30th September 2011

Application No. 2011/1057

REFERENCE: PROPOSED CHANGE OF USE TO INCLUDE B2, JUMBO SELF DRIVE LTD.,
2A SHEFFIELD ROAD, BIRDWELL, BARNSELY. SOUTH YORKS. S70 5UZ.

Project: Proposed M.O.T. Service Facility,
2A Sheffield Road, Birdwell,
Barnsley. South Yorks. S70 5UZ.
Scale: 1/250 @ A3. Dwg. No. SRB/YDL/05A
Title: Proposed Site Plan. Date: 30.09.11.

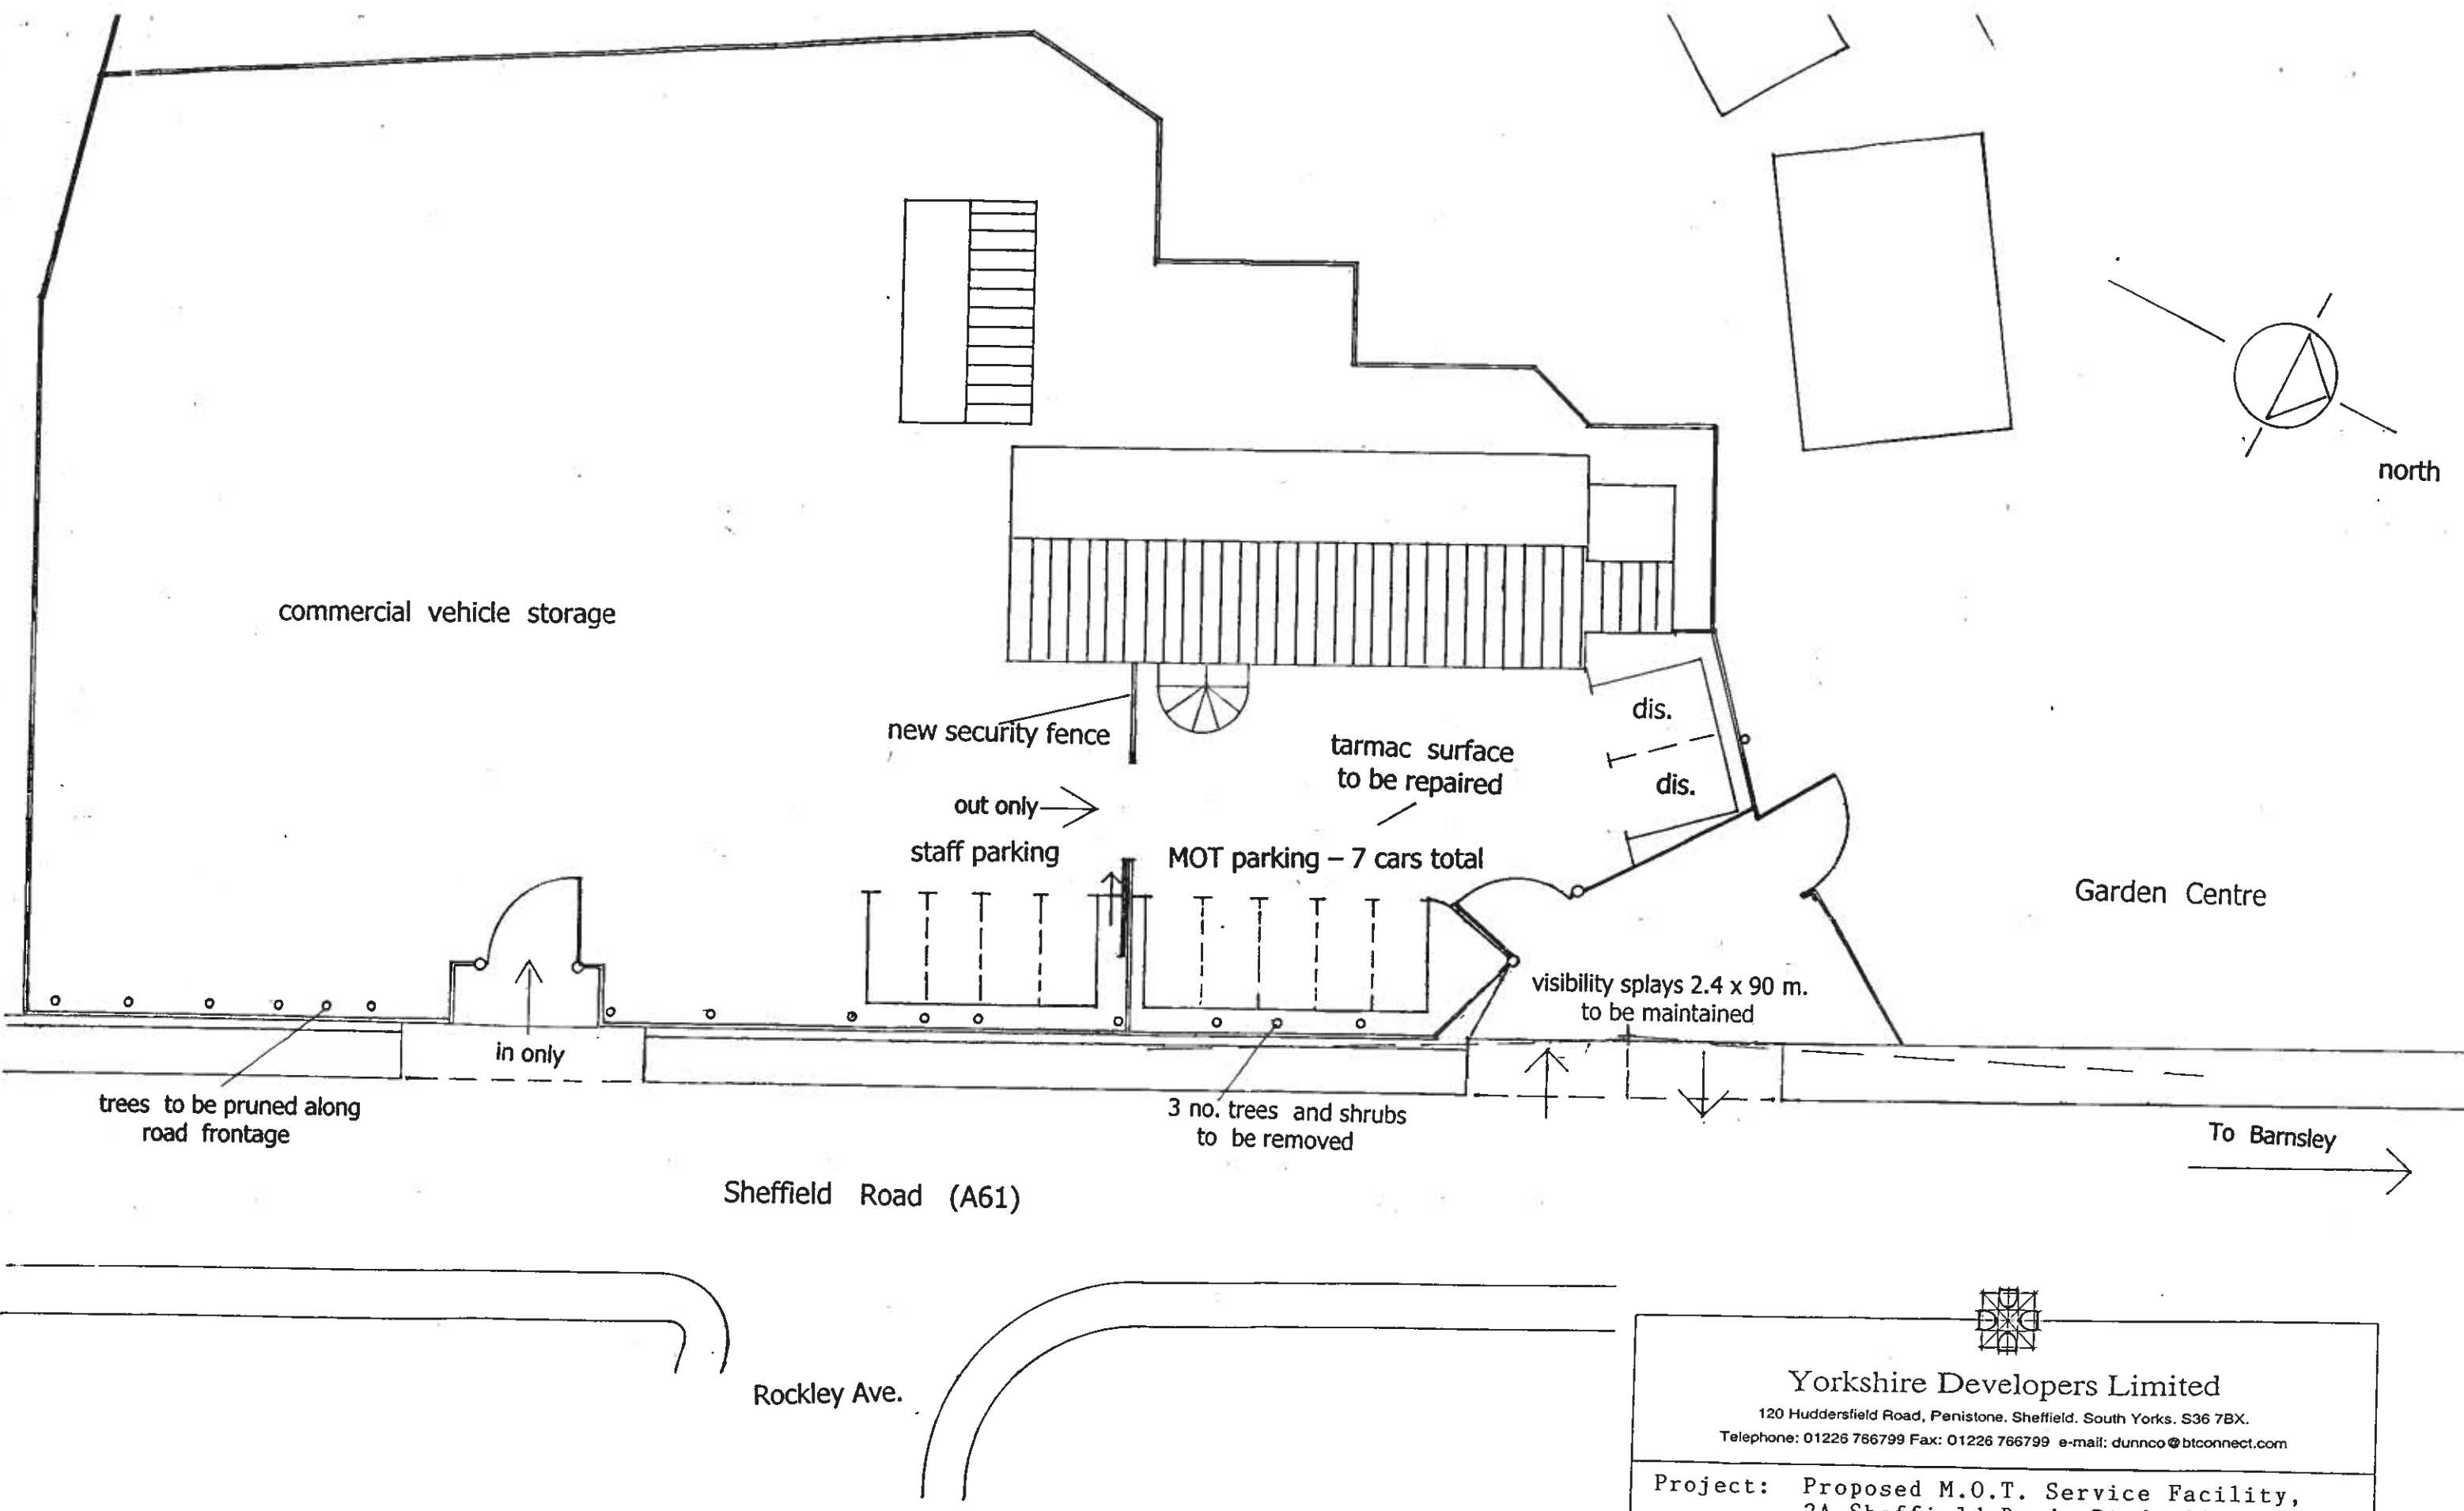
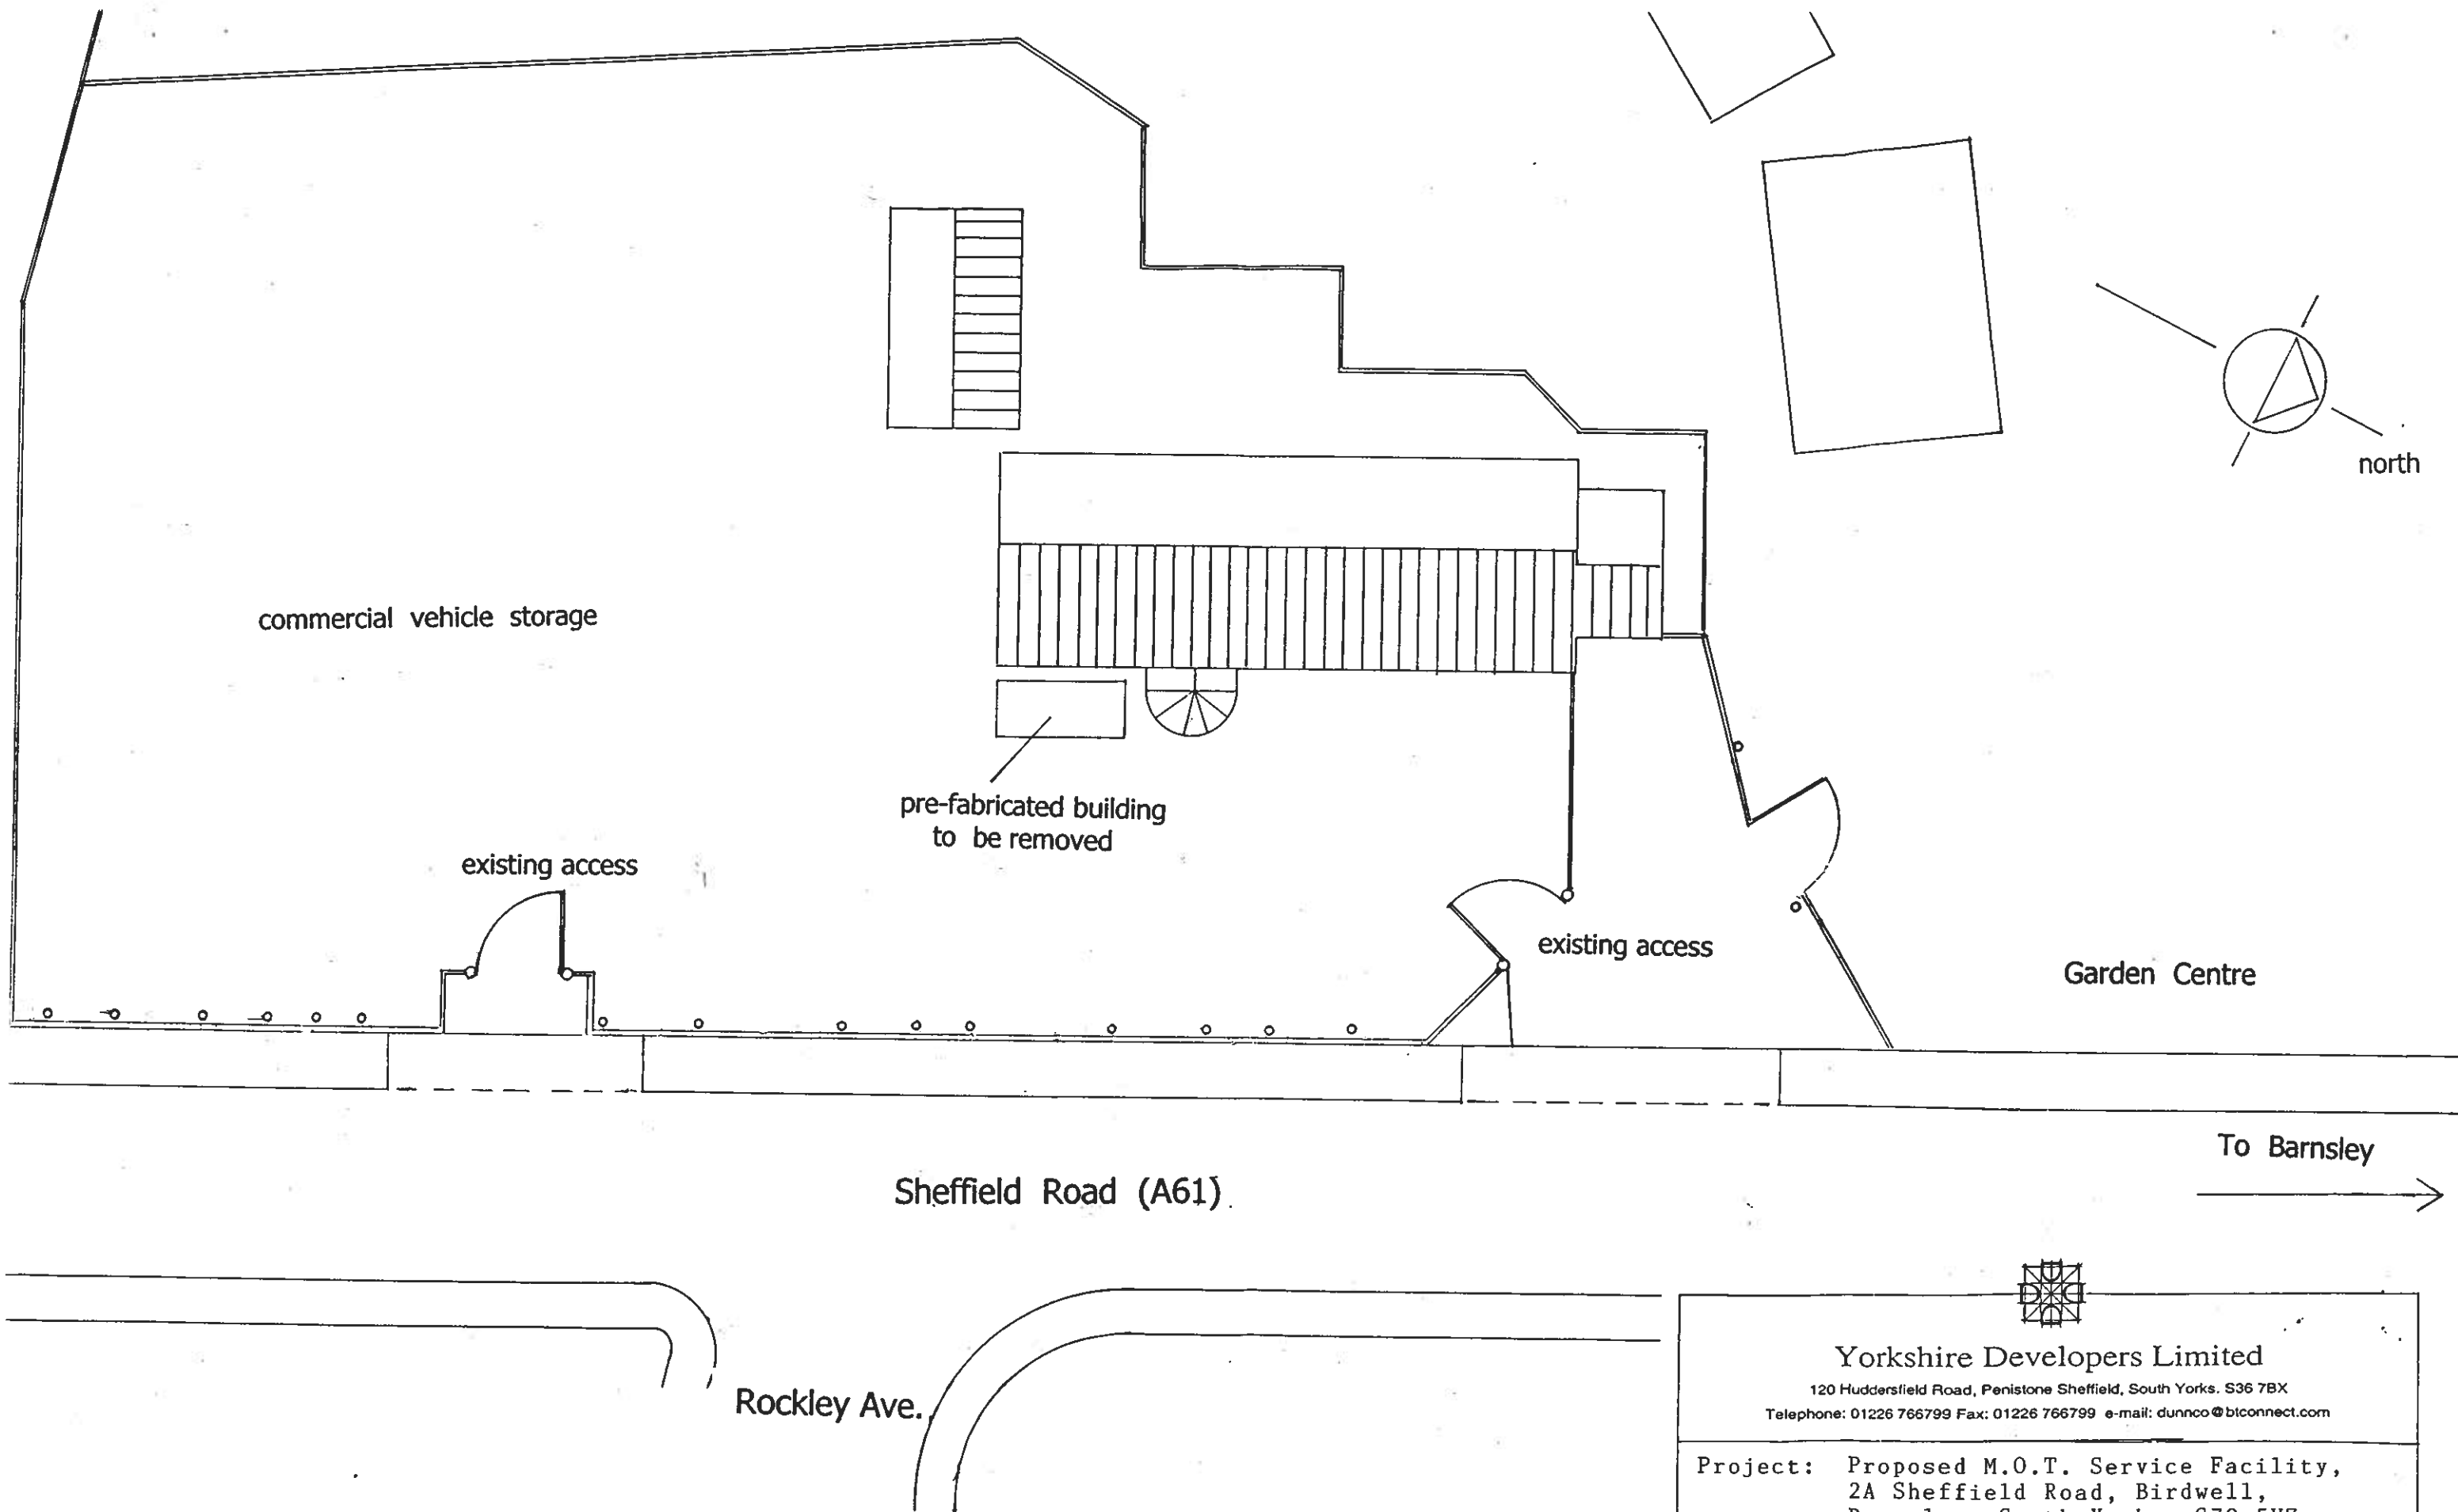
With reference to the Comments made by Mr. Ellam, I confirm:-

1. The access/egress from the subject premises is capable of having the visibility splays as requested without the security fence being moved because behind the 1.80 m. footpath is a 0.30 m. landscaped area in front of the security fence.
2. The vegetation will be removed and maintained to achieve the above visibility splays.
3. Existing access no. 1 will be used for vehicles entering the commercial parking area and these and other vehicles will be able to leave through the new security fence via the sliding gate between the commercial parking area and the M.O.T./Service facility.
4. With regard to the long term future of the substandard access, the owner has been made aware that if there is an increase in traffic flow, he will have to make improvements to this access as required by Environmental Services.
